Application for a Non-Material Amendment Following a Grant of Planning Permission

Two storey side extension following demolition of existing attached garage, single storey rear extension, loft conversion with dormer to rear roofscape, porch to front, and outbuilding to rear

22/02425/FUL

P-003 revision B

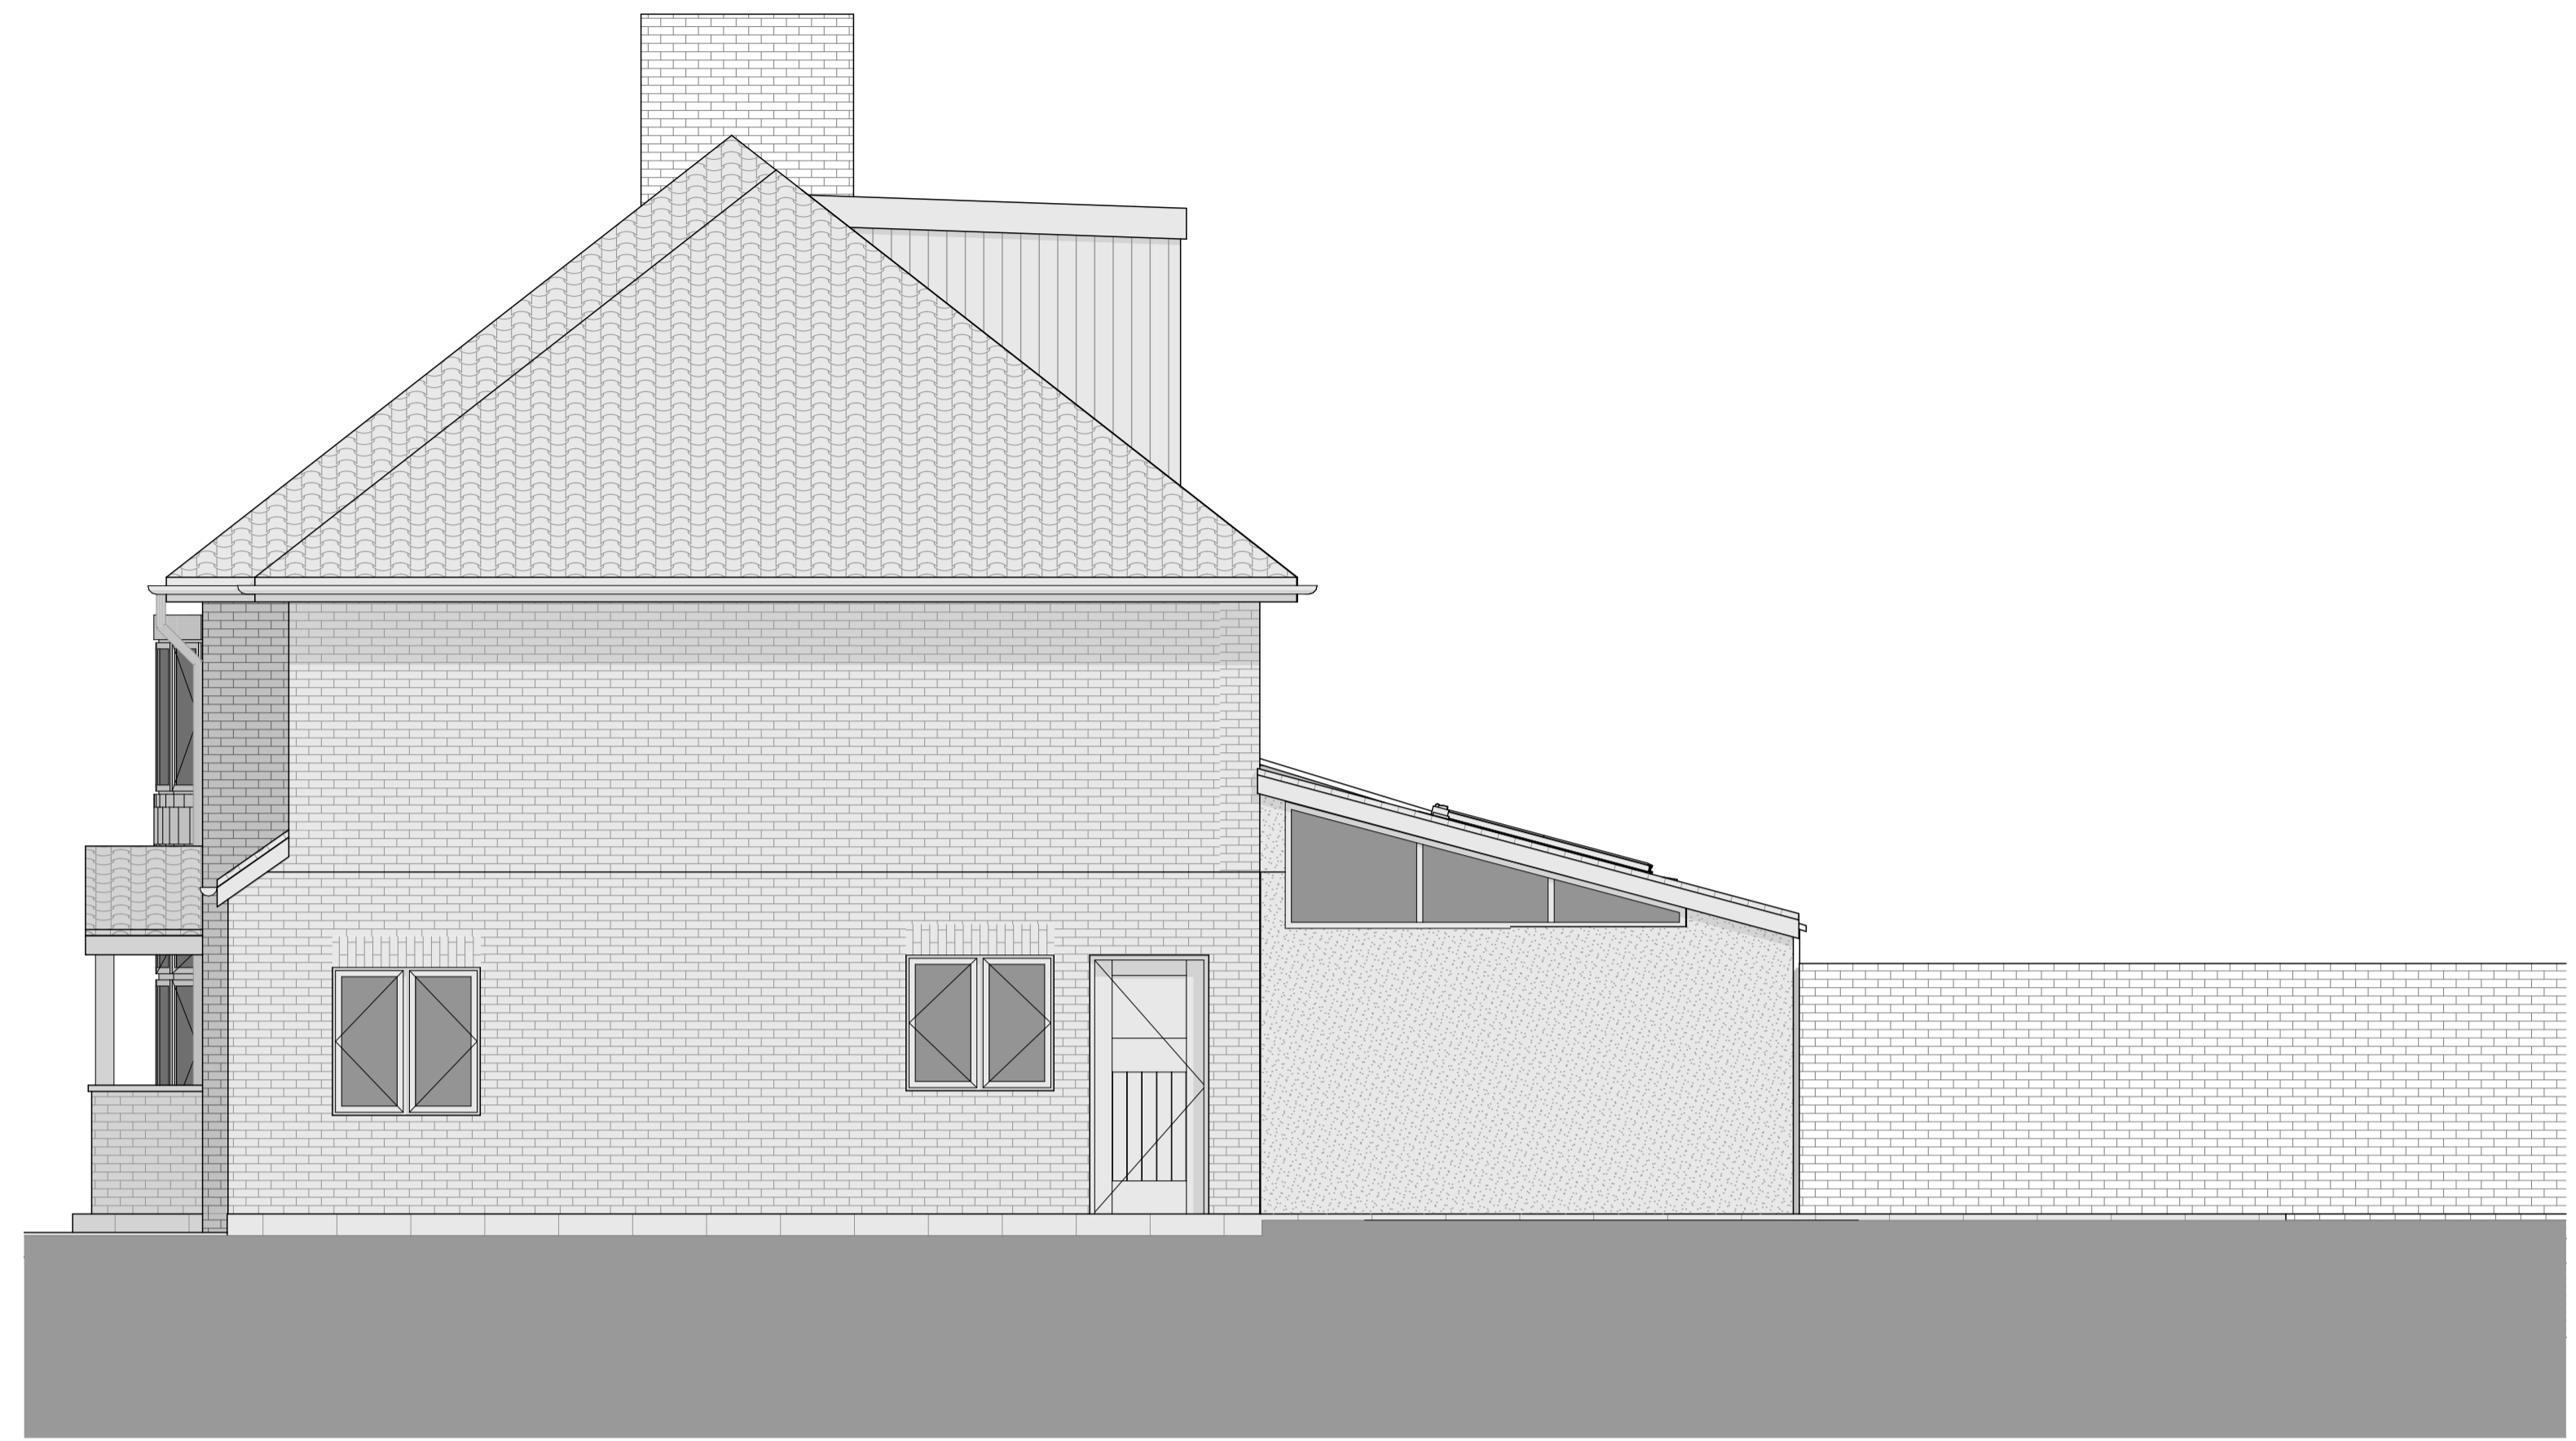
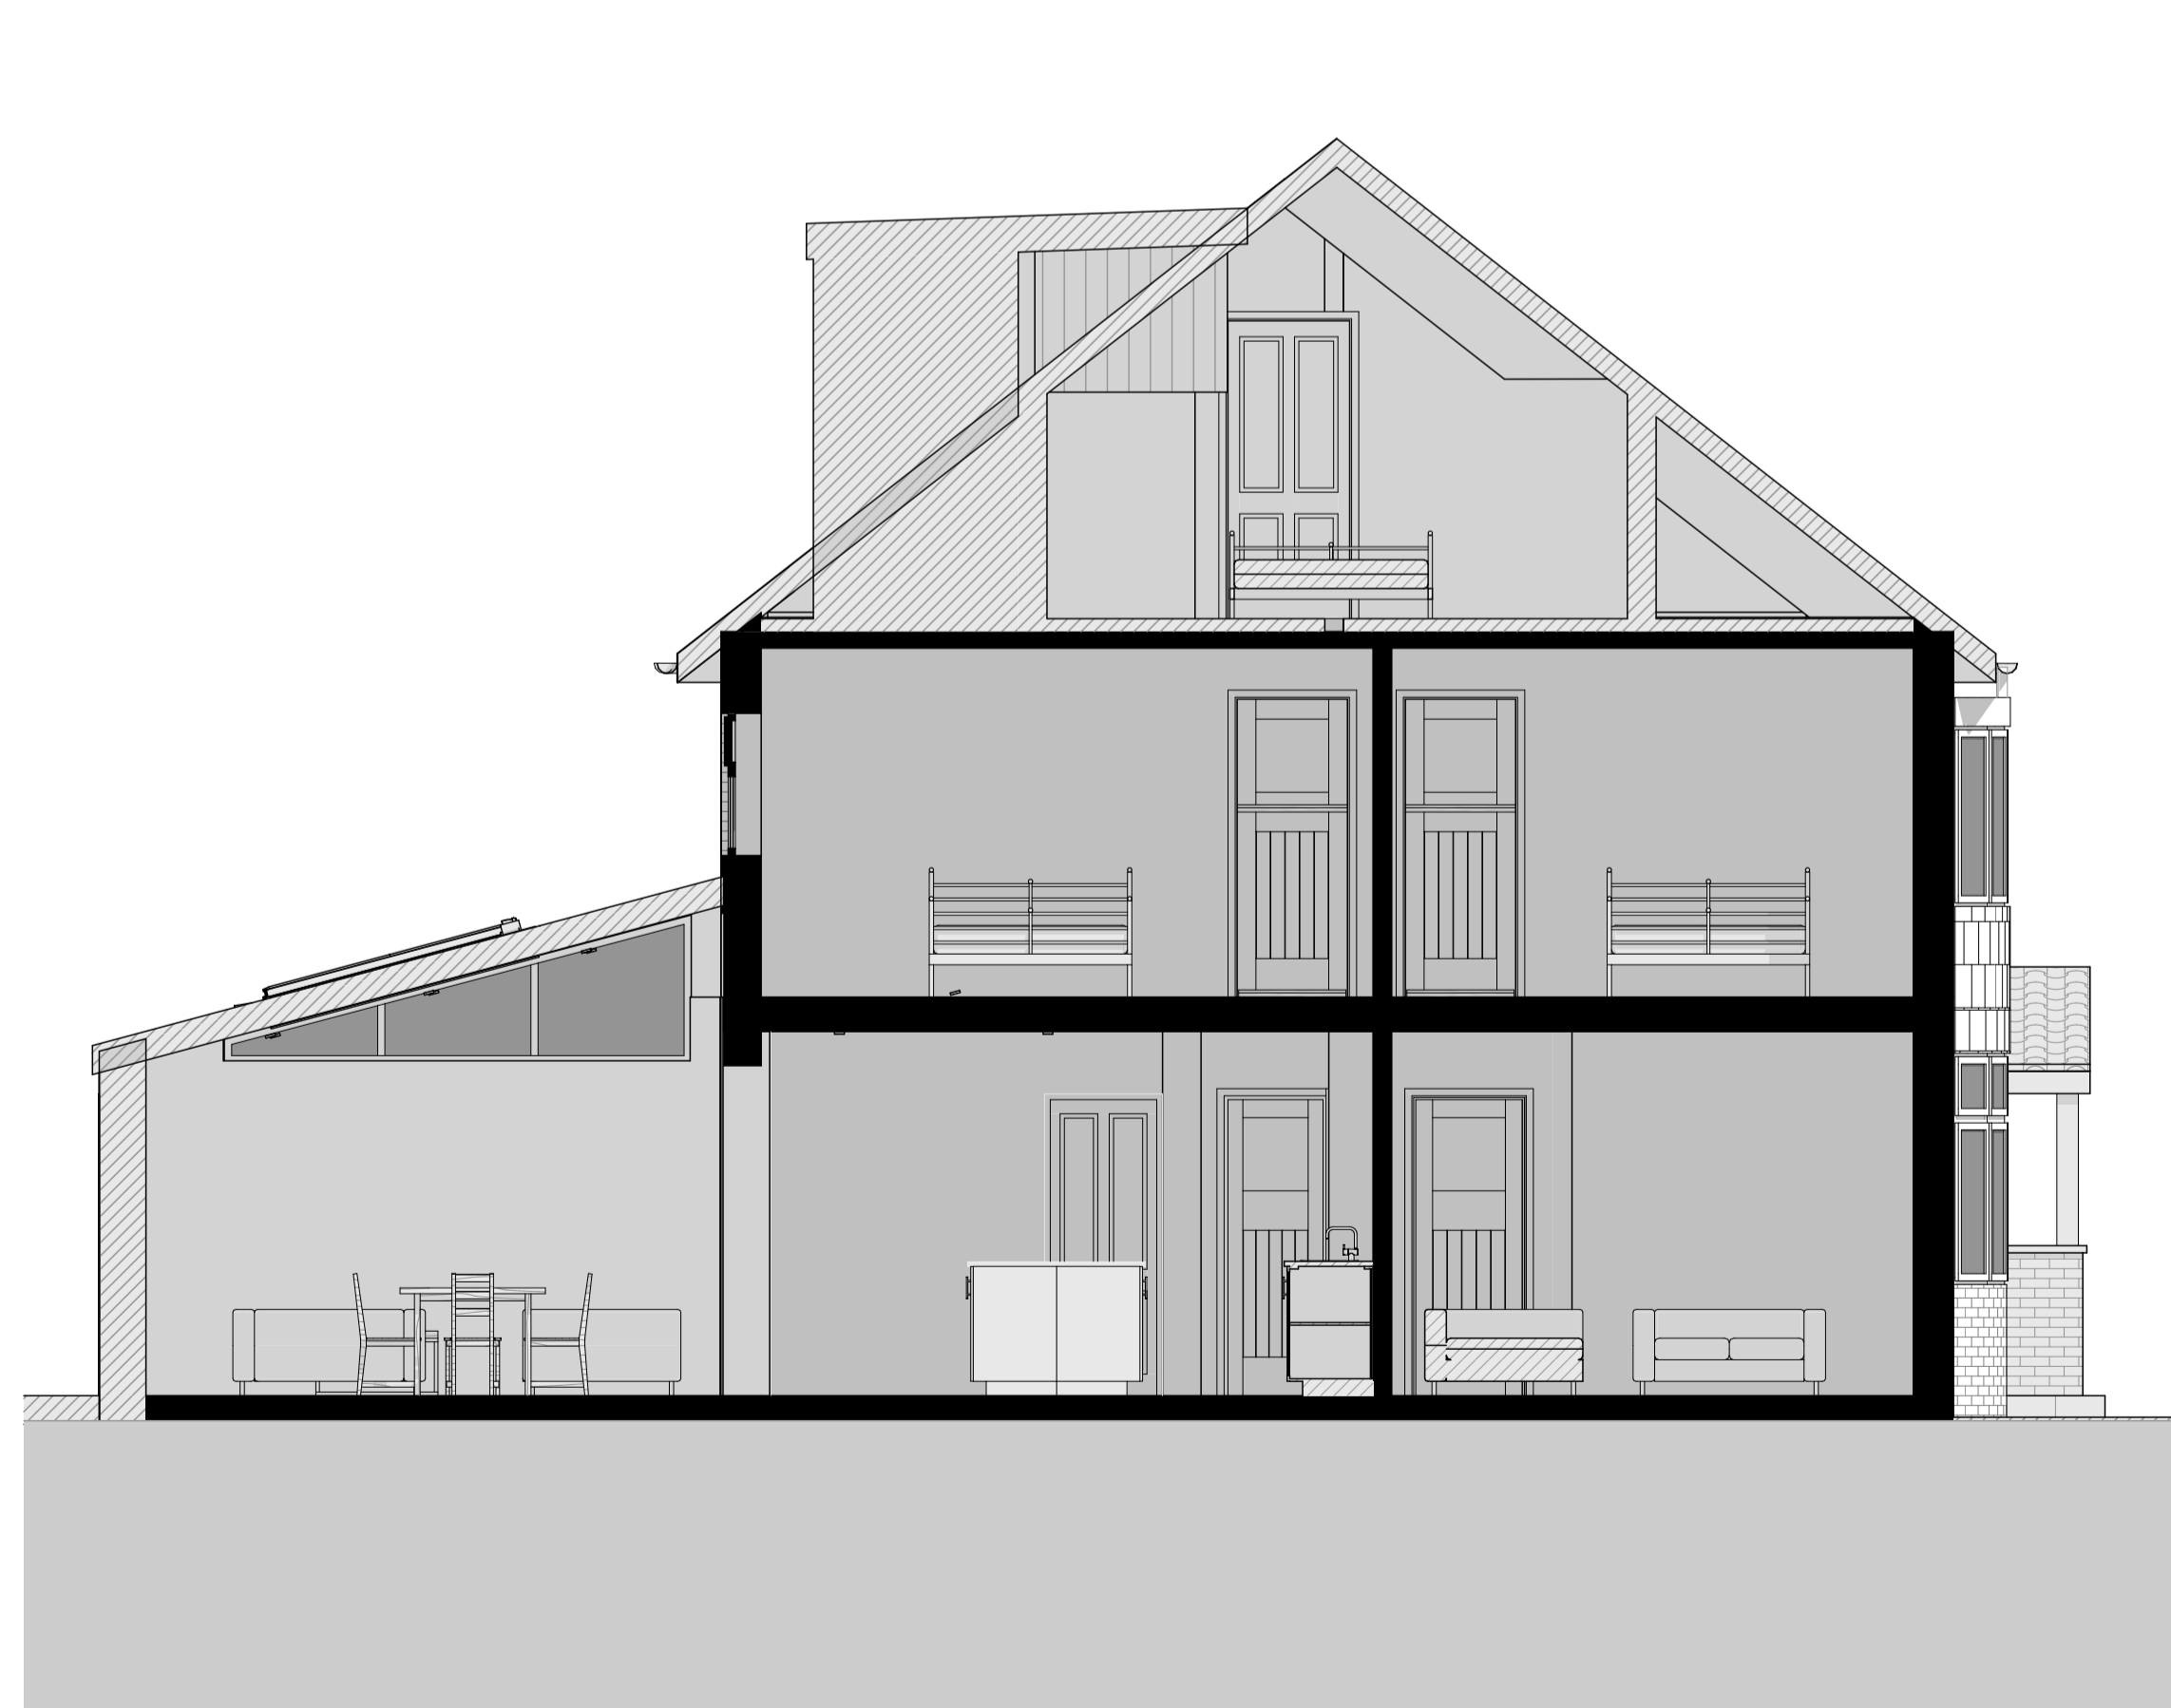
To remove the first floor window on the east elevation (2)
To remove one rooflight on the extension pitched roof to have a total number of 3 skylights.
